CITY OF ALBUQUERQUE

November 9, 2017

Re: Sandia Acrobatic Gymnastics Academy
3400 Candelaria Rd. NE
Traffic Circulation Layout
Architect's Stamp 09-29-17 (H16D152)

TCL

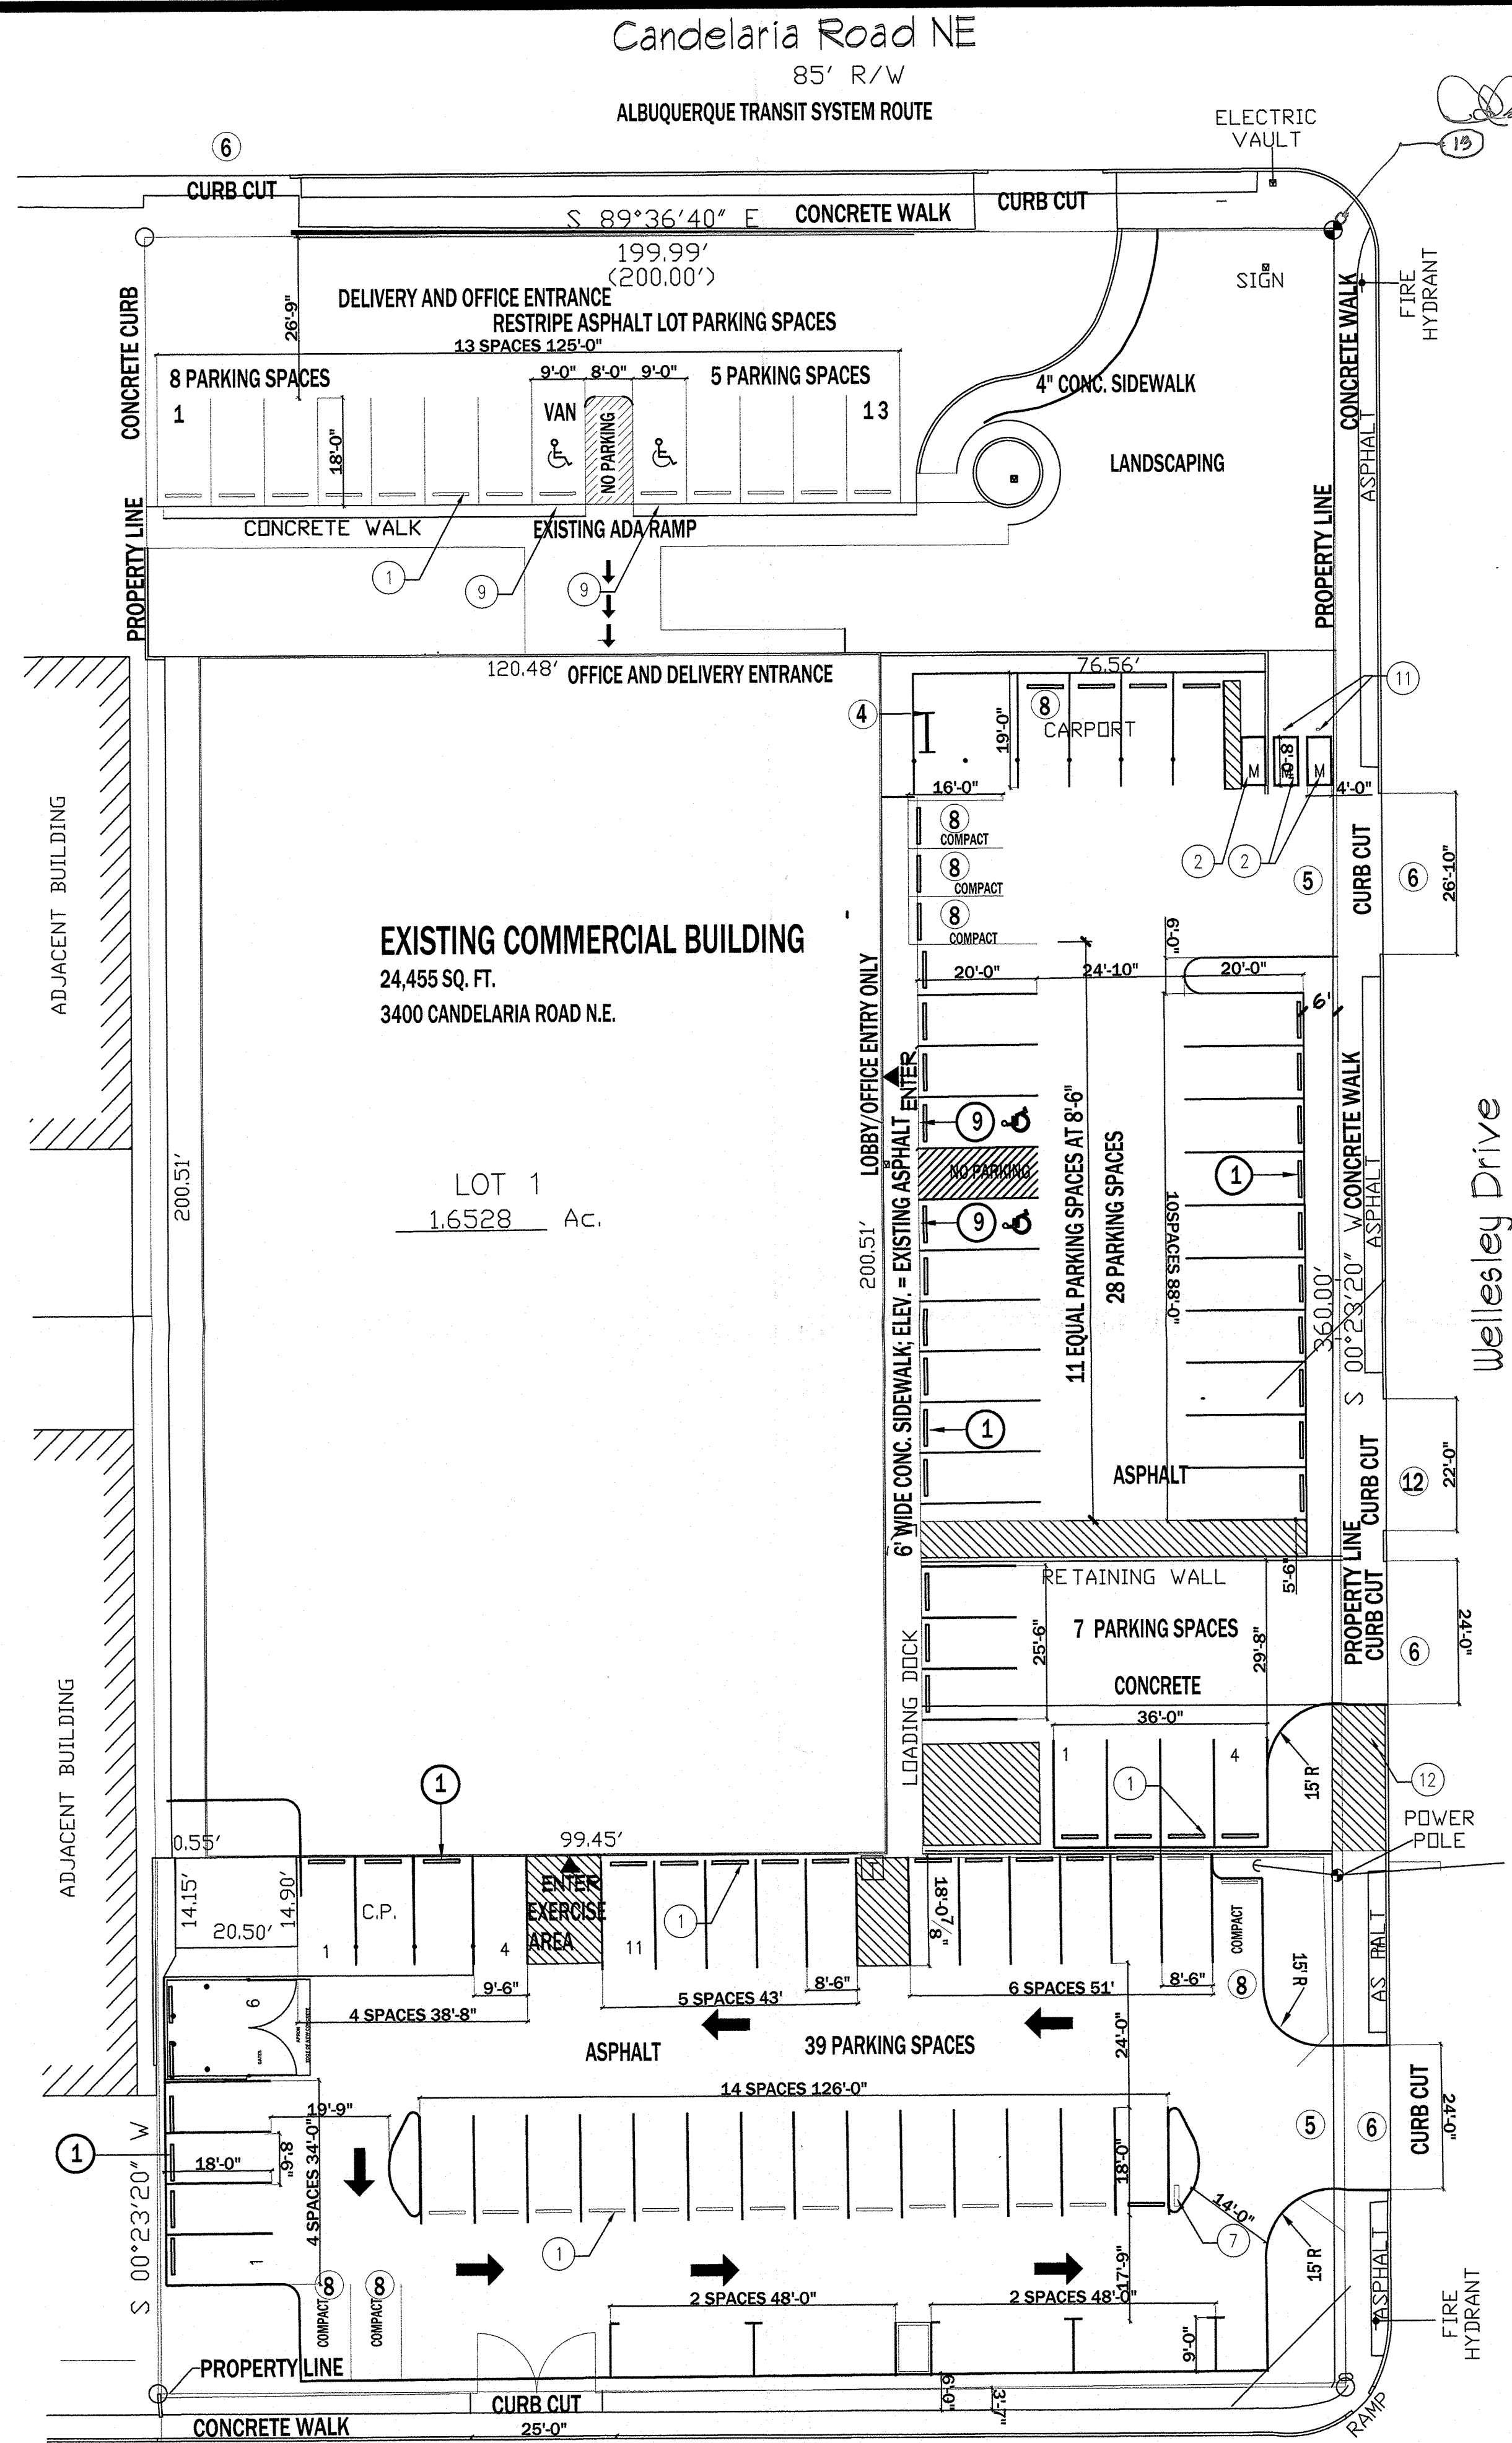
1. Add a scale to the plan view.
2. Please list the width and length for all existing and proposed parking spaces. Some dimensions are not shown. Provide the lengths of the parking stalls where no dimension is shown.

3. The compact spaces at the north of the site look like they are standard size.
4. ADA curb ramps must be updated to current standards and have truncated domes installed. The ADA ramp on Candelaria Rd. and Wellesley Dr must be updated to current ADA standards.

5. Motorcycle parking spaces should be dimensioned. The motorcycle space closed in by parking spaces will not be allowed. Provide the # of required motorcycle spaces.

6. Please dimension all new and existing curb cuts on site.
7. List radii for all curves shown; for passenger vehicles, the minimum end island radius for passenger vehicles is 15 ft. Radius for delivery trucks, fire trucks, etc. is 25 ft. or larger. Please indicate the radii on the end islands.

8. A 5 ft. keyway is required for dead-end parking aisles.
9. One-way vehicular paths require pavement directional signage and a posted **"Do Not Enter"** sign at the point of egress. Please show detail and location of posted signs. The 18 foot curb cut is not big enough for two way travel must be a minimum of 24 feet.

10. Please specify the City Standard Drawing Number when applicable.
11. Unused curb cuts must be replaced with sidewalk and curb & gutter. A build note must be provided referring to the appropriate City Standard drawing. The

drive entrance next to the loading dock must be closed with curb, gutter and sidewalk.
